# CITY OF ALBUQUERQUE

**Re: 9700 Trumbull  
Erosion and Sediment Control Plan  
Engineer's Stamp Date 8-16-17 (L20E051)**

Based upon the information provided in your submittal received 8-17-17, the above referenced plan is approved to be included in the SWPPP and to apply for an ESC Permit for grading and Building Permit and to be included in the Work Order construction plans with the following conditions:

EROSION AND SEDIMENT CONTROL PLAN

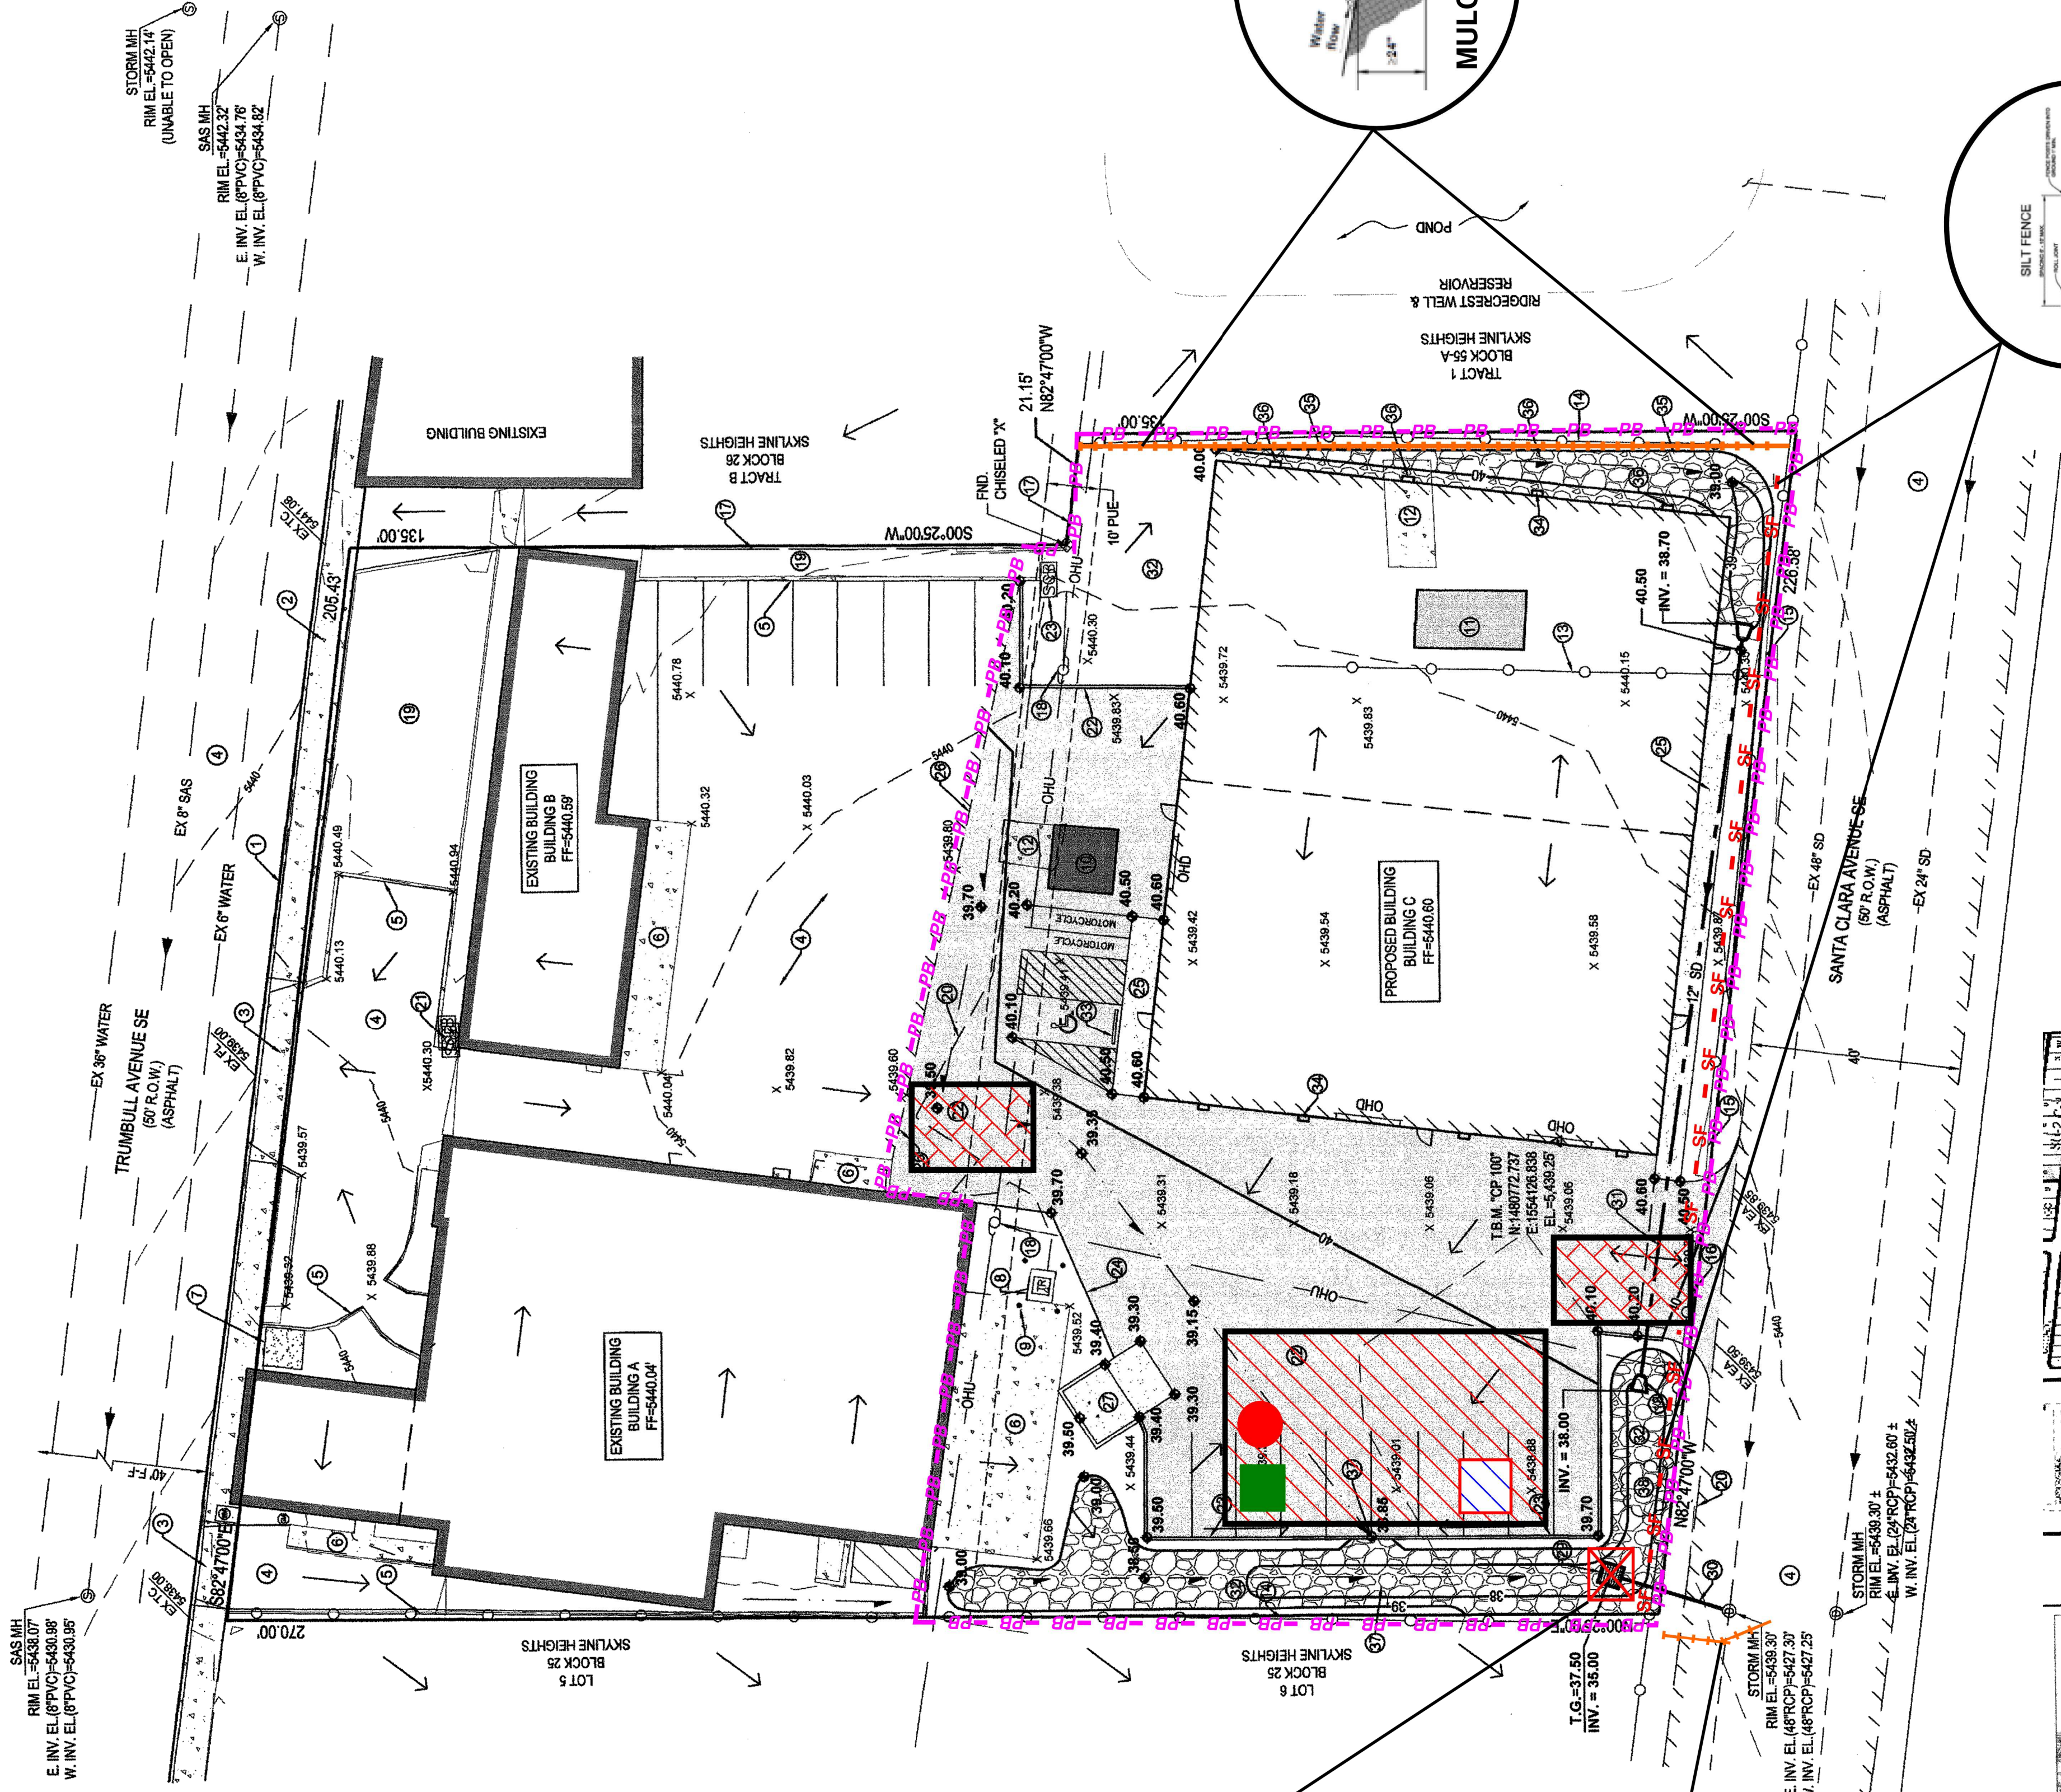
1. The ponds are to be graded with the initial grading of the site. Please inform the owner/contractor.
2. The plan is approved for construction activities as shown on this plan. If additional construction activities are shown on the Work Order construction plans or other plans, an additional or revised Erosion and Sediment Control plan may be required.
